# Architectural Design Competition Report

57-61 Archer Street and 34 Albert Avenue, Chatswood

September 2023

**FIGURE 2 GROUND FLOOR PLAN**

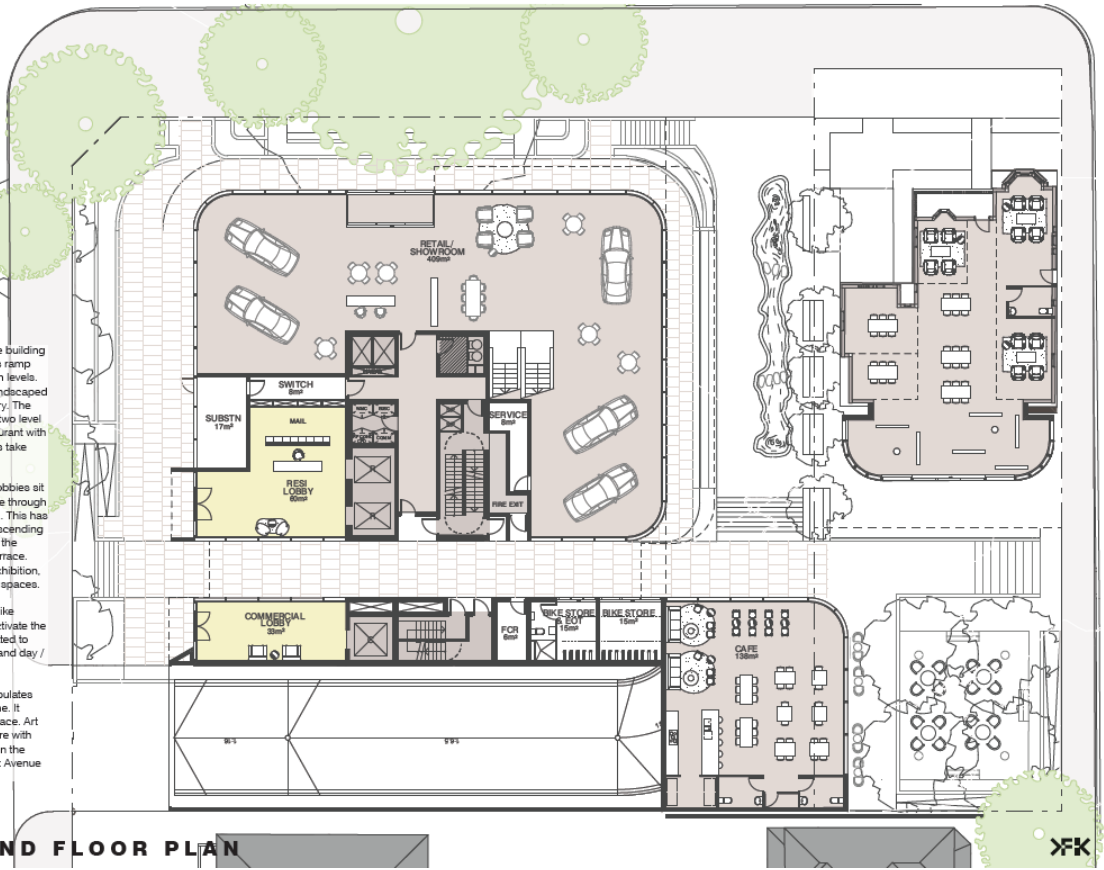
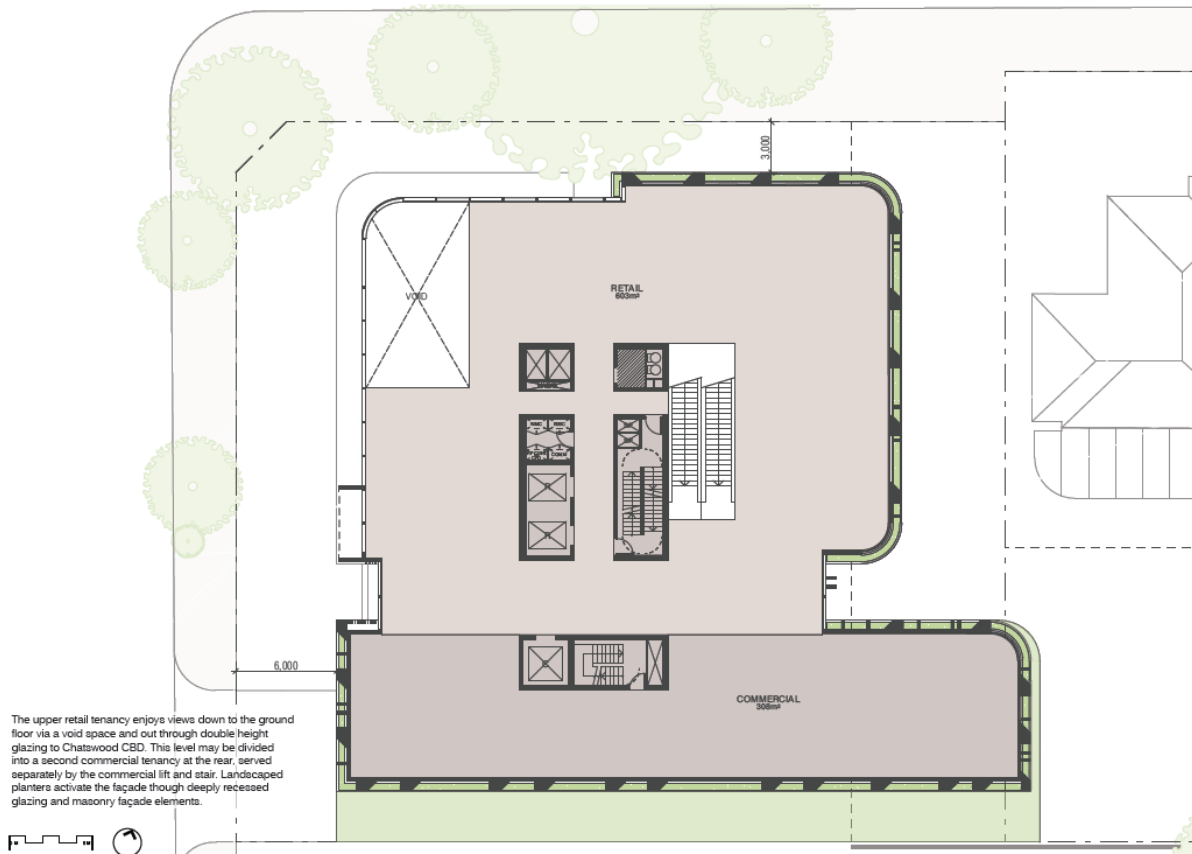
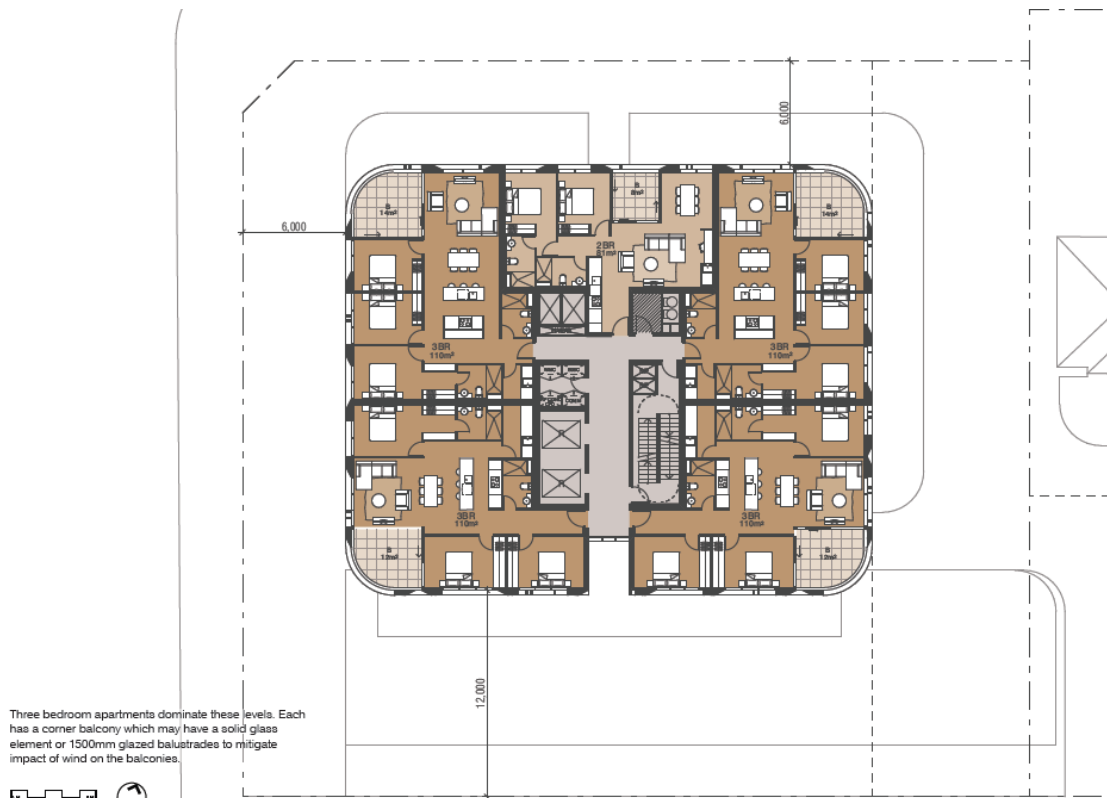
- the overall visual complexity of the tower and podium facades;
- the introduction of a mid-tower recess/break on level 13 which interrupts the vertical proportions of the tower massing and its perceived slenderness;

- the environmental performance of the facade including the depth, alignment and spacing of the vertical blades and the lack of aspect-specific consideration in their configuration;
- the amenity and comfort of the exposed corner balconies;
- the design and distribution of apartments does not appear to respond adequately to prospect or amenity;
- the number and proportion and of living spaces in three bedroom apartments;
- the relationship between the communal pool and the adjacent apartments results in acoustic and privacy concerns;
- the comparatively low performance of cross ventilation;
- potential complexities regarding fire egress within the arcade link;
- the functionality of the loading dock / turntable; and
- the intention to add a contemporary addition to the heritage building given the extent of new building form on the site.

**FIGURE 7 GROUND FLOOR PLAN**  
 Source: PBD Architects

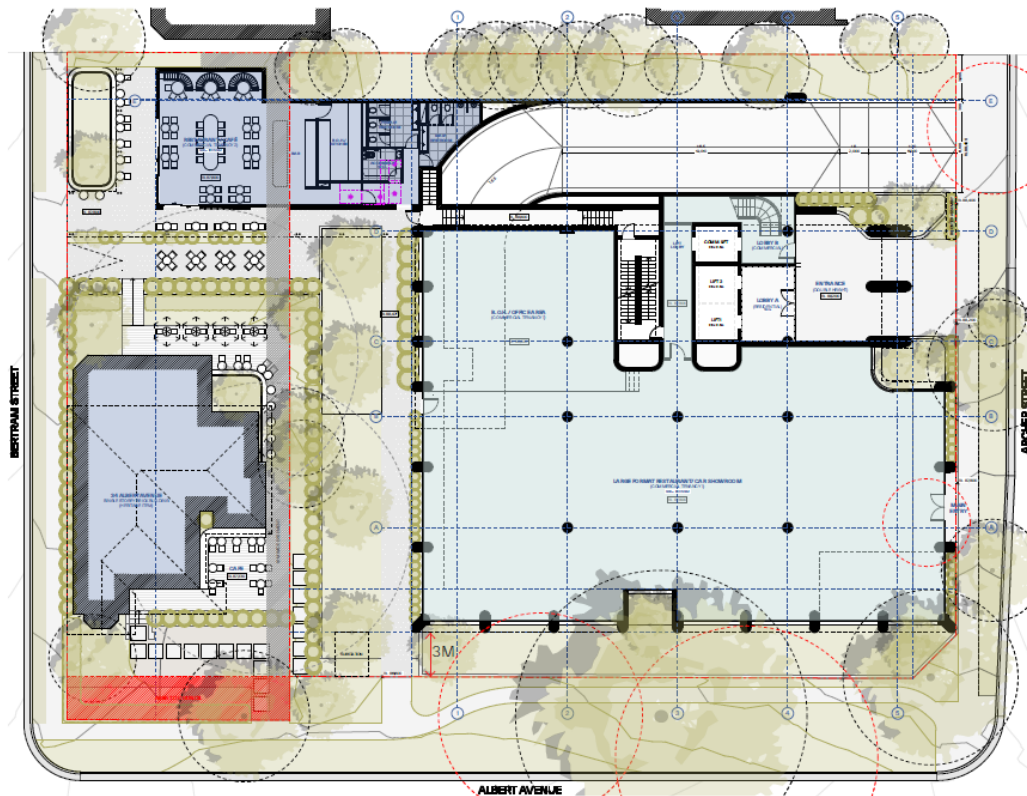
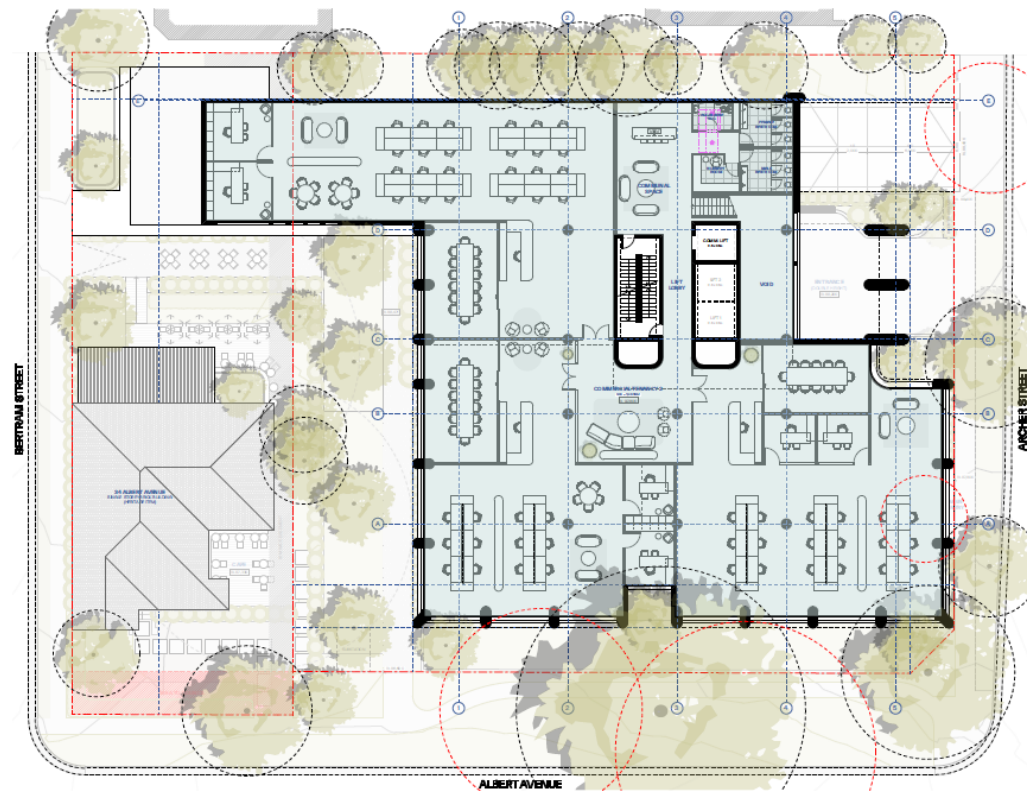
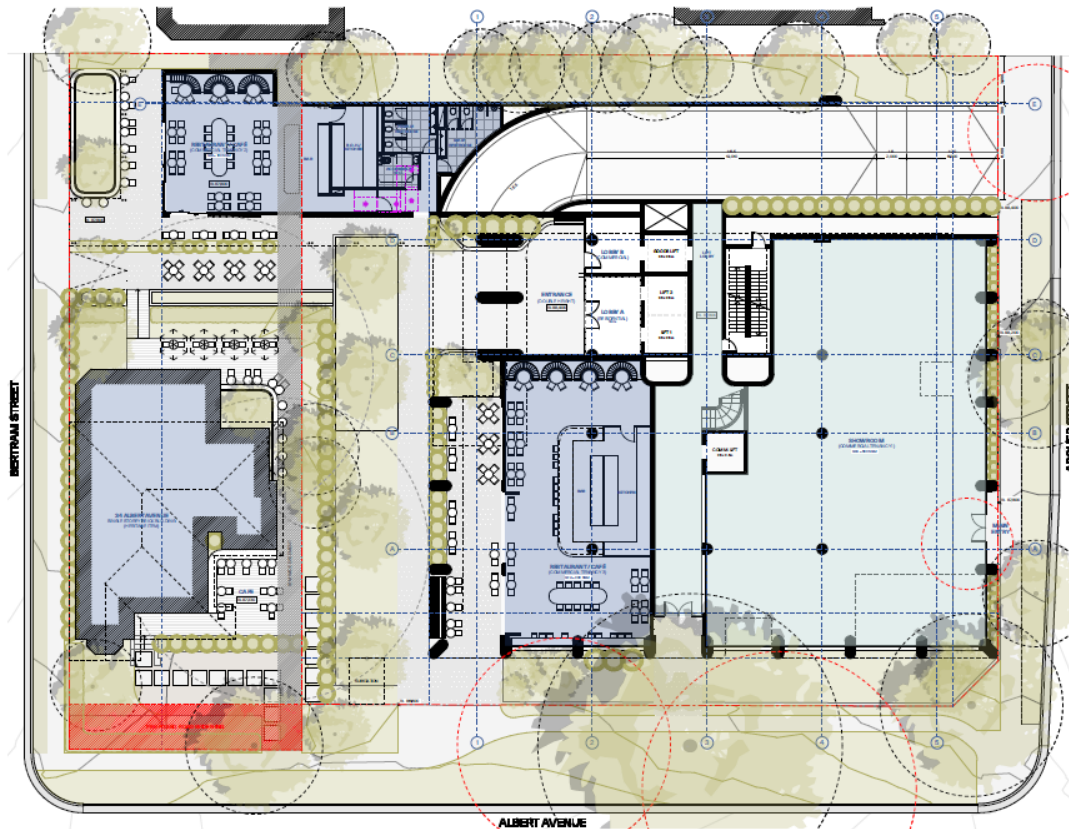
- the design and configuration of apartments e.g. high proportion of inboard living areas that do not take full advantage of the relative slenderness of the building to be located on the corners of the tower;
- the effectiveness of natural ventilation with flow paths through ensuites and walk-in wardrobes;
- the resolution of fire egress in the options presented;
- the architectural expression of the annex building;
- the lack of consideration of the southern podium and tower façade; and
- the disconnect between the rendered views and the tower plans regarding blade walls and columns raising questions about what the resulting expression, materiality and detailing.
